CITY OF ALBUQUERQUE

June 4, 2018

RE: **Utility Trailer Sales**
8201 Daytona Rd NW
Grading Plan Stamp Date: 5/25/18
Drainage Report Stamp Date: 5/14/18
Hydrology File: K09D026B

RE: Utility Trailer Sales
8201 Daytona Rd NW
Grading Plan Stamp Date: 5/14/18
Drainage Report Stamp Date: 5/14/18
Hydrology File: K09D026B

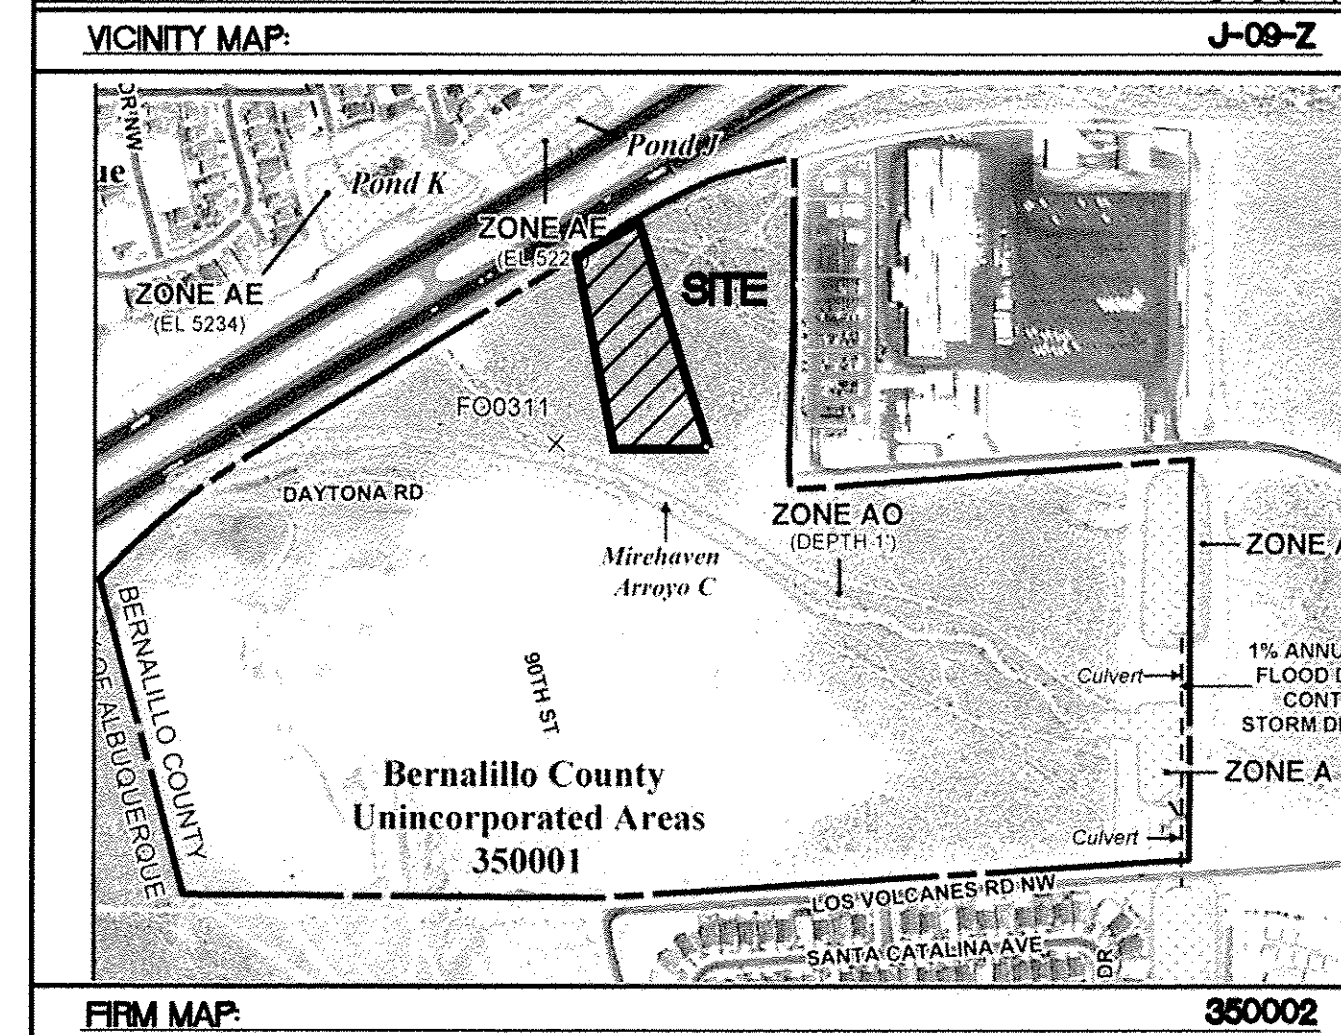
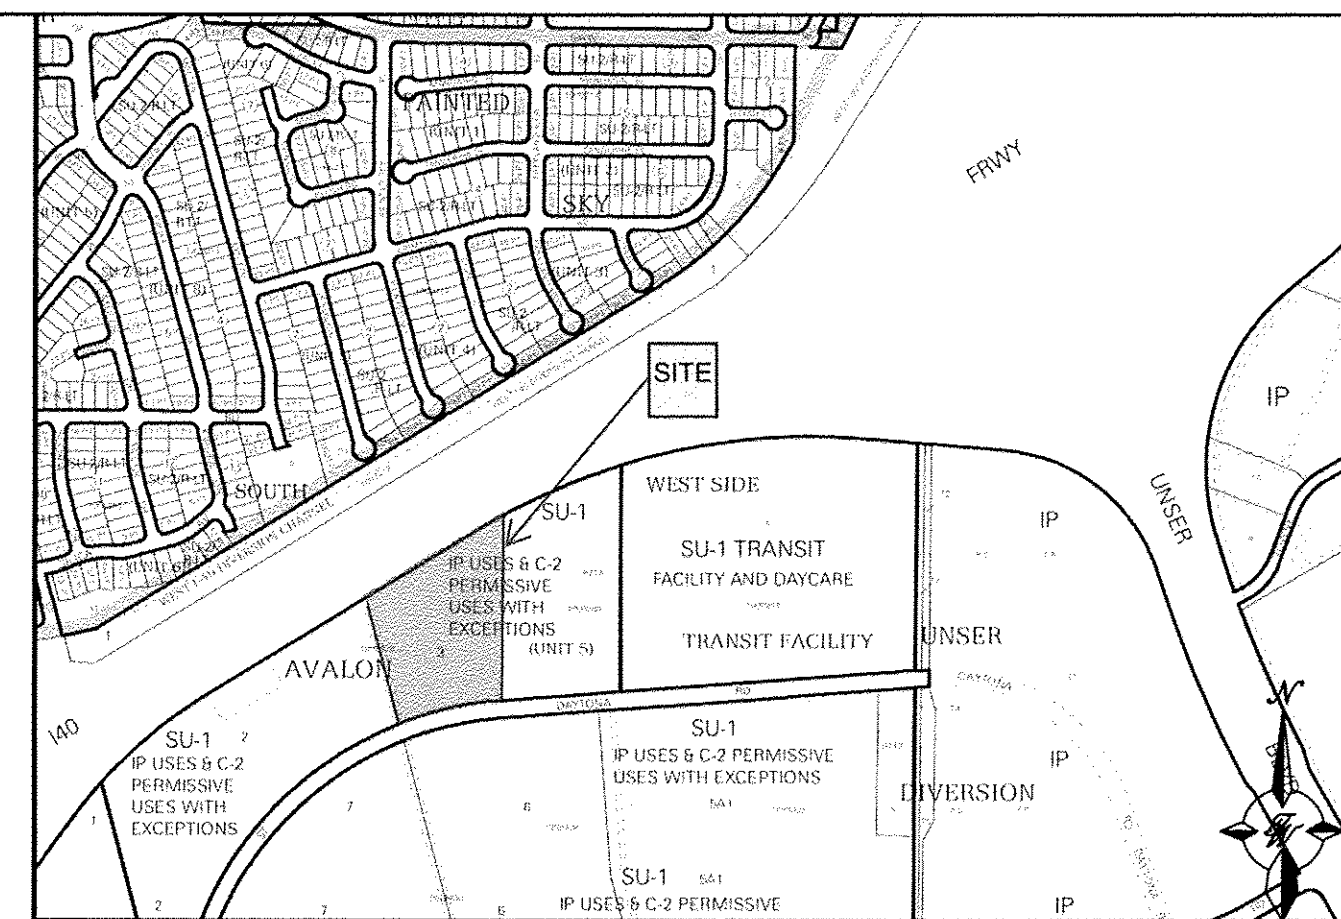
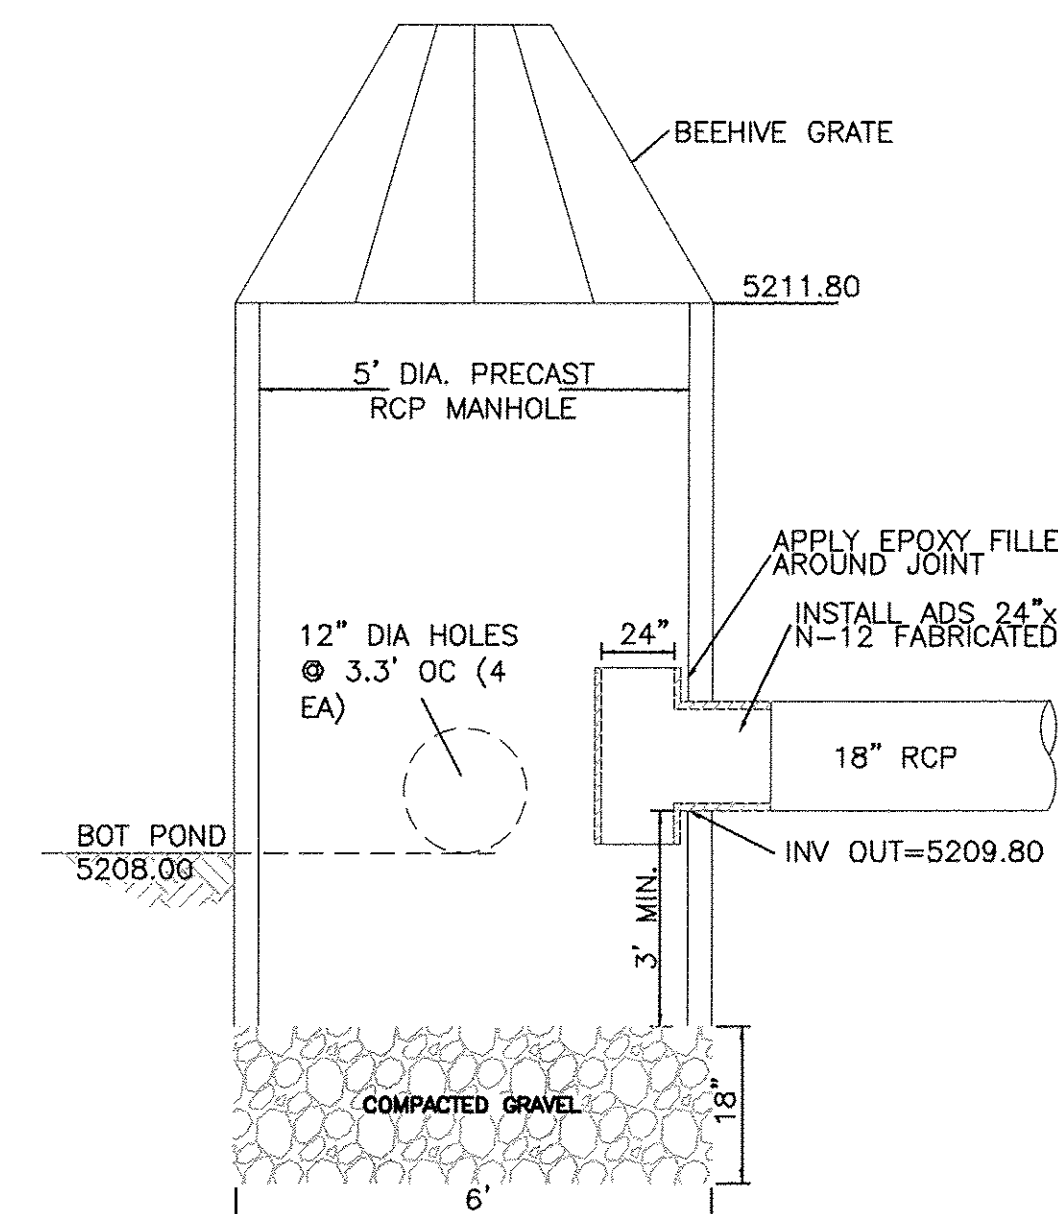
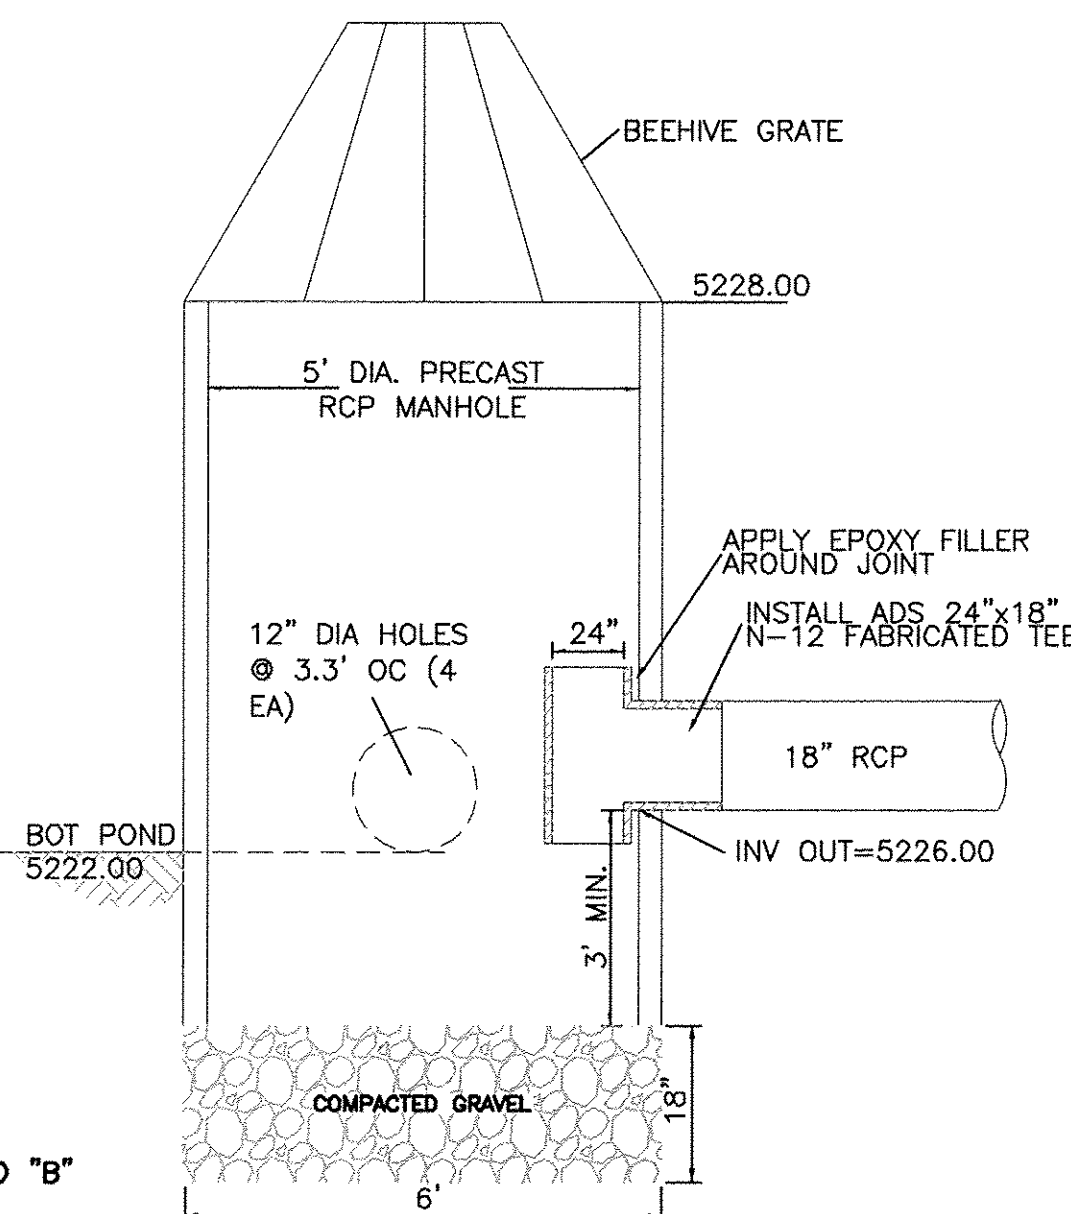
1. The grading in the SE corner of the site does not support the proposed drainage pattern. For instance the contours and spot elevations do not indicate a swale along the property line, connecting the two first flush ponds. The SE corner is lower than the InvertOut of the adjoining pond riser (5012.00' vs ~5010.20'-5011.00'). The grading in this area will need to be reworked to ensure a clear flow path from Pond A to Pond B to the 18" RCP into Daytona. Pond B bottom and InvertOut will likely need to be lowered.

2. There are a few proposed spot elevations and contours across the property line onto Bruckner's property. Please correct to show no grading across the property line here. If this work is required, written and signed permission will need to be obtained from the property owner.
